## New single Family home on Peaks Island - Frederick Avenue (Lyndon Ave.) - Permit #2016-00873

I have completed my initial zoning review and there are some things that I need before I can complete my zoning review.

1ST FLOOR PLAN
A-1.2
FOR PERMIT
NOT FOR
CONSTRUCTION

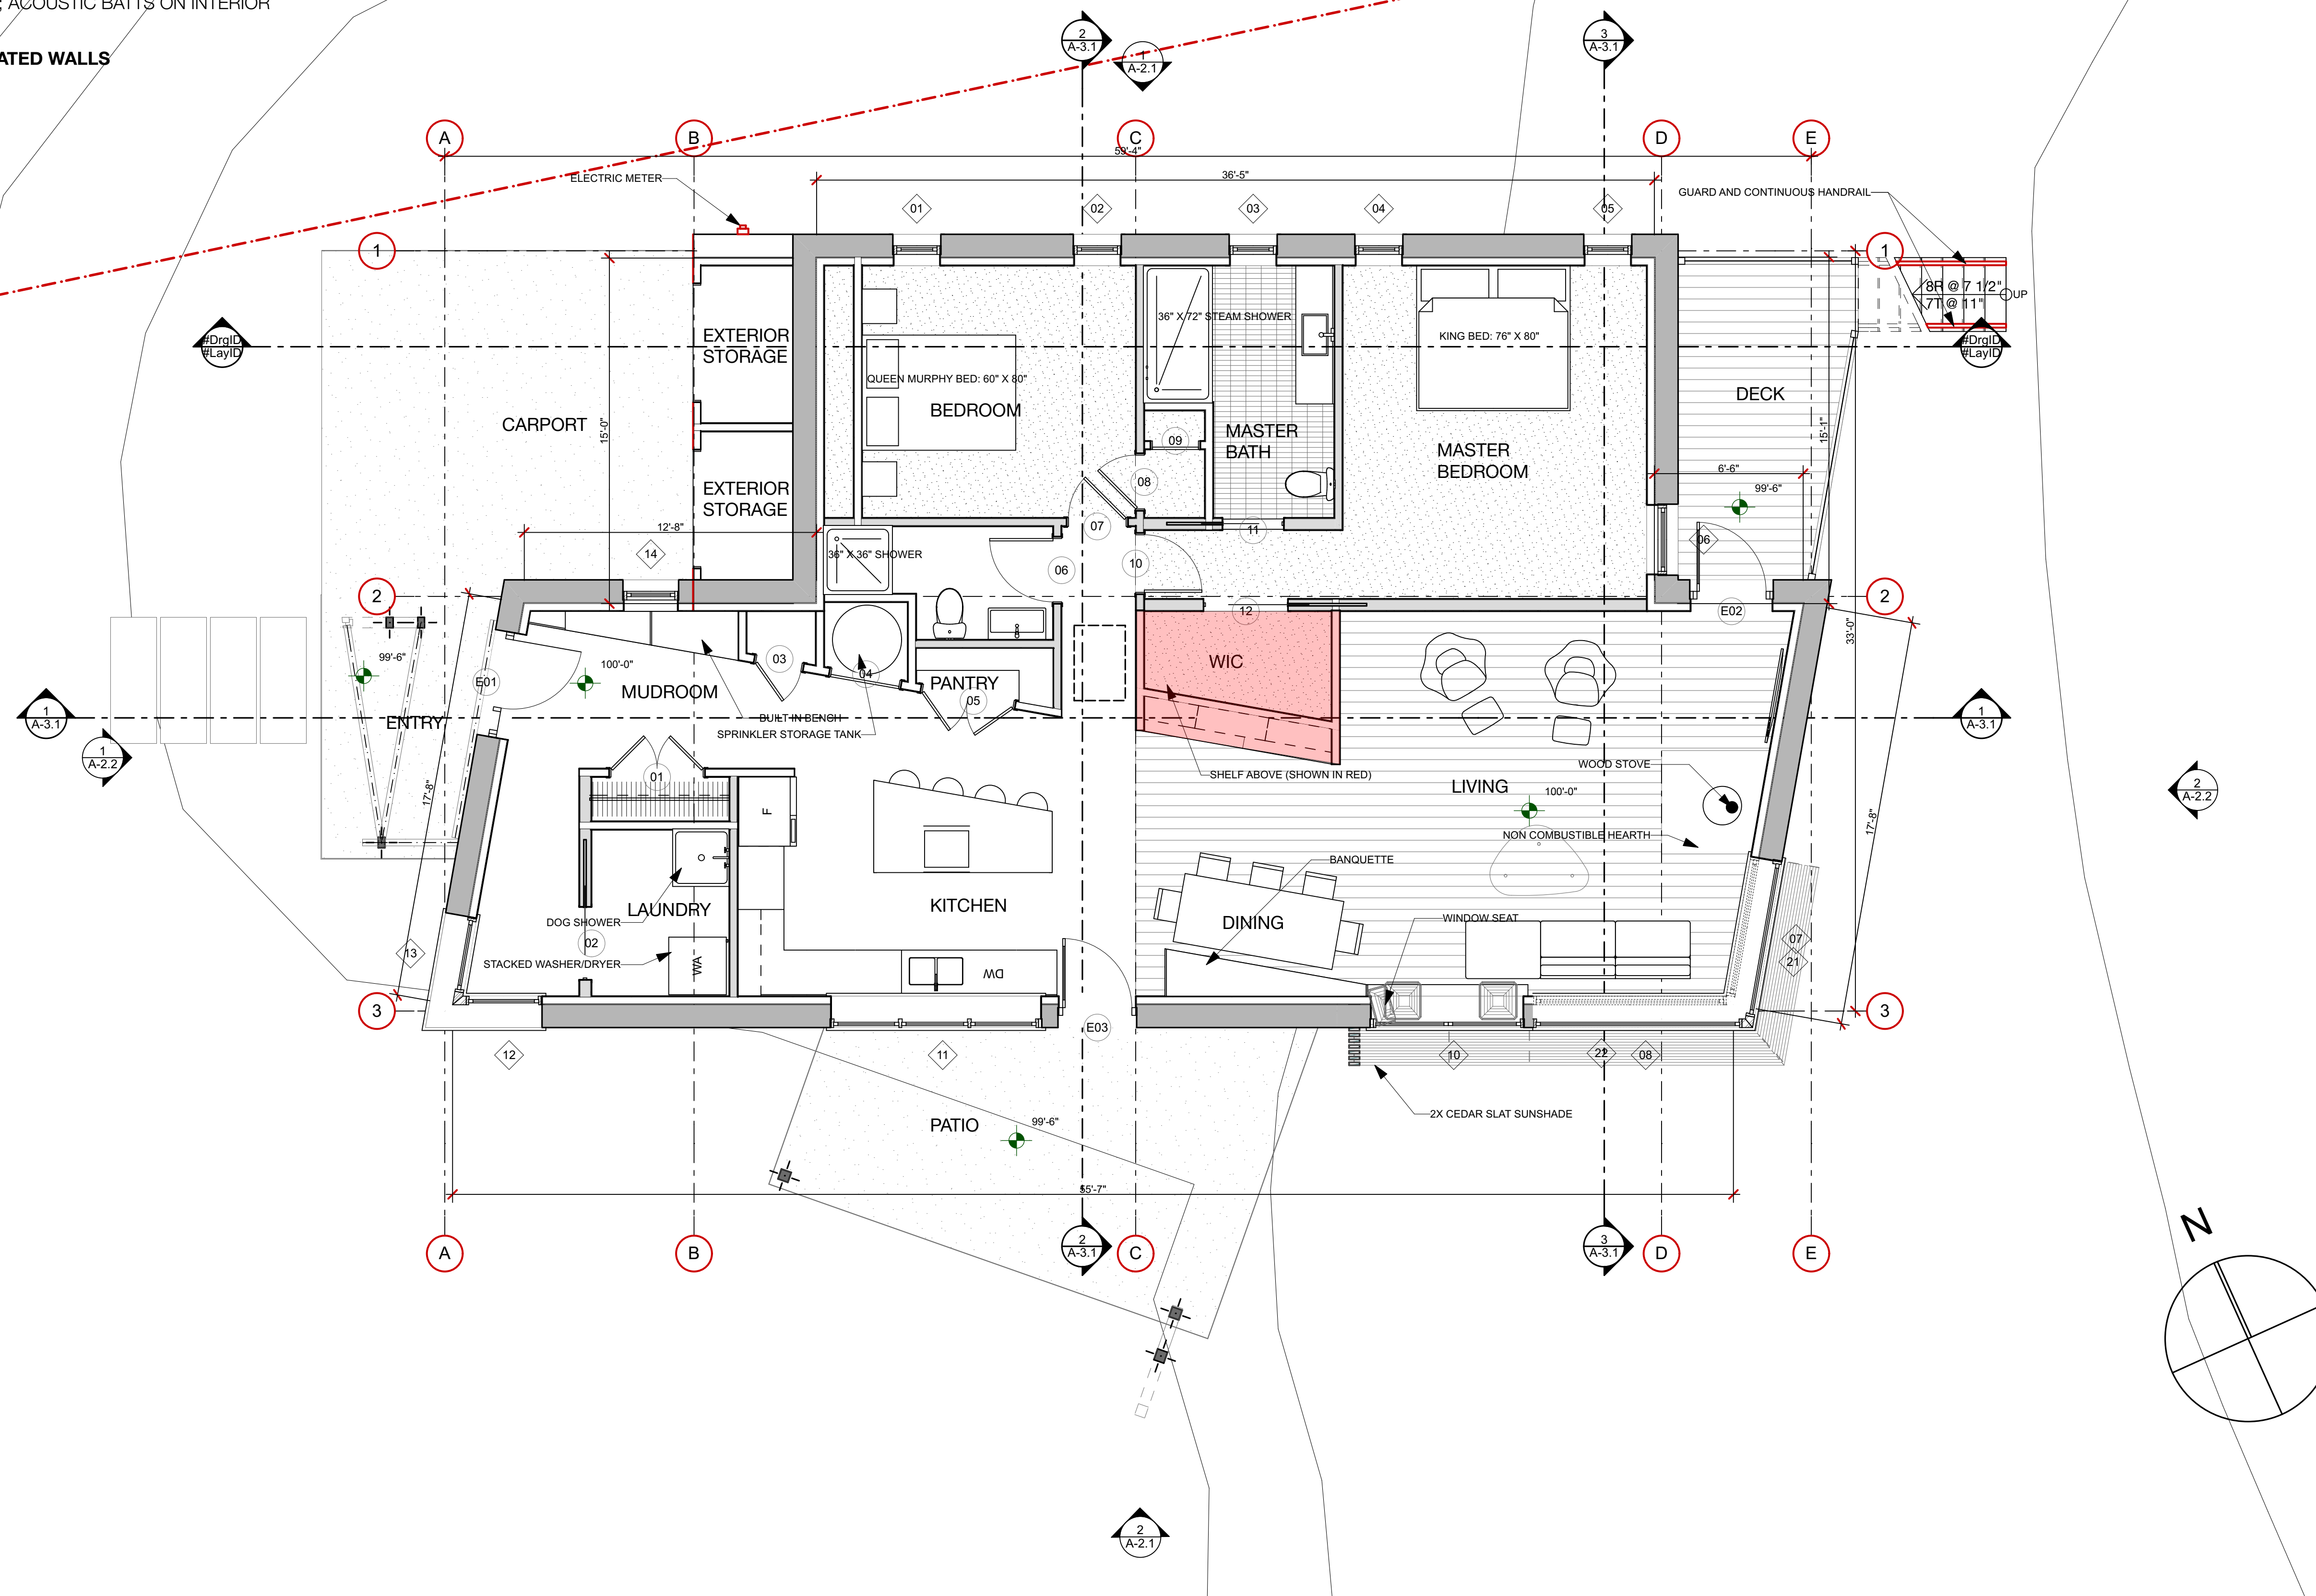
3. Speaking of the required parking spaces, plan A-1.2 shows a carport. It appears to scale at 14.35' x 16'. A parking space must be 9' x 18'. Please show two parking spaces on the site plan that meet this criteria.

See revised site plan

**1 SITE PLAN**  
SCALE: 1/16" = 1'-0"

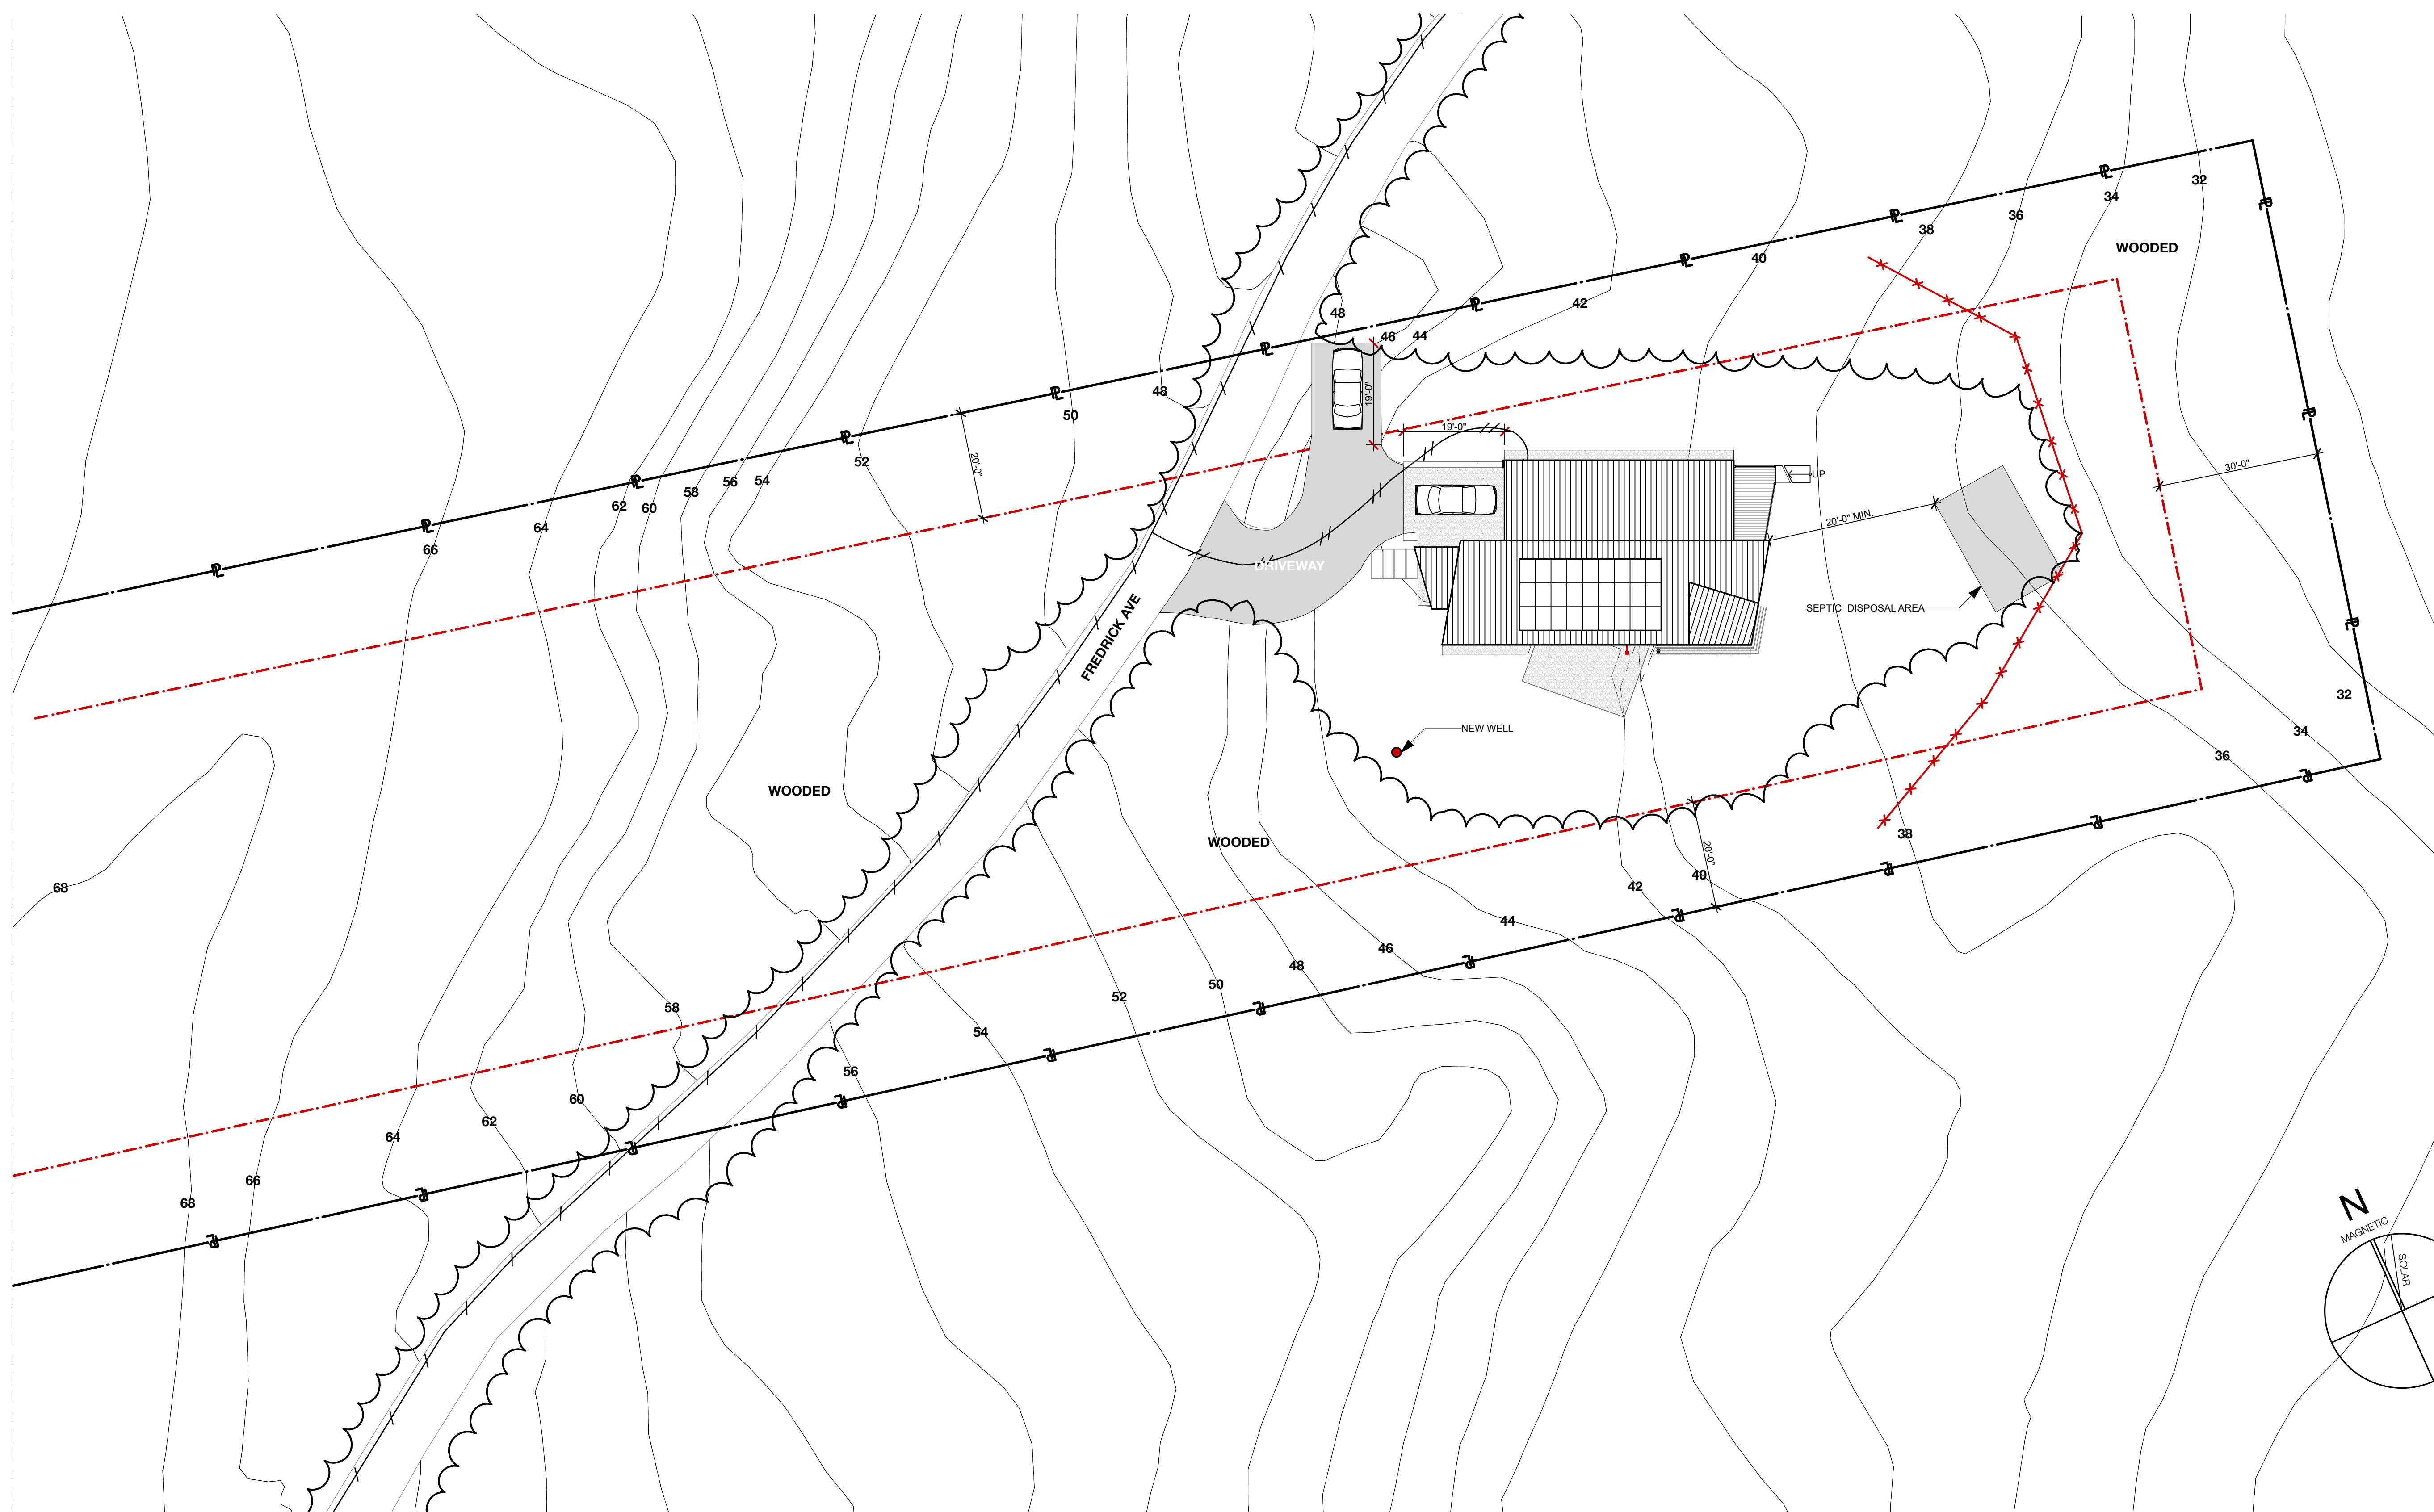
I need to determine that this section is being met. I have concluded that this lot meets the definition of a lot of record under section 14-433. As a lot of record, "access can be provided by a permanent easement or right of way. This easement or right of way must be a minimum of 16' wide and have a minimum travel width of 8'. The survey that was submitted with the application done by John Swan from Owen Haskell, Inc. shows Frederick Ave as a "path" that crosses the middle of the lot. This "path" scales at about 8' in width. On the site plan it appears to scale at over 9'. (The actual width is hard to determine because of the

line with the single hash marks that runs through the lot on the path and branches off to the new house with two hash marks. There is no key on the site plan so it is unclear what this line is.) The original Plan Book, BK 13, Pg 81 (attached), for this lot (2B) shows Frederick Ave as a 40' wide right of way that ends at the southern side of the lot and then is labeled as a trail that runs through the property. I need confirmation that where Frederick Ave enters the southern side of the lot that it has a travel width of at least 8' so that the required access is being met.

In addition to this, you are required to have two parking spaces for a new single family home. Is the "path " that is shown going to be the driveway to access the new house?

4. What is the 14.4' x 23' gray rectangle on the site plan that is shown 20' off the back of the house? Is it a structure or a septic system?

5. Is the lot served by public water? If not is there a well?

I believe the path is wider than 8', we comfortably drove a car down Fredrick Ave last fall. Maybe the builder, who lives on Peaks, could measure and confirm? Heather Thompson is cc'd on this email. The line with single hash marks is above ground electric - double hash marks is below ground electric, see revised site plan.

See revised site plan that more clearly shows the driveway and 2 parking spaces with dimensions

Septic

Well, see revised site plan. We missed the note on the permit set.
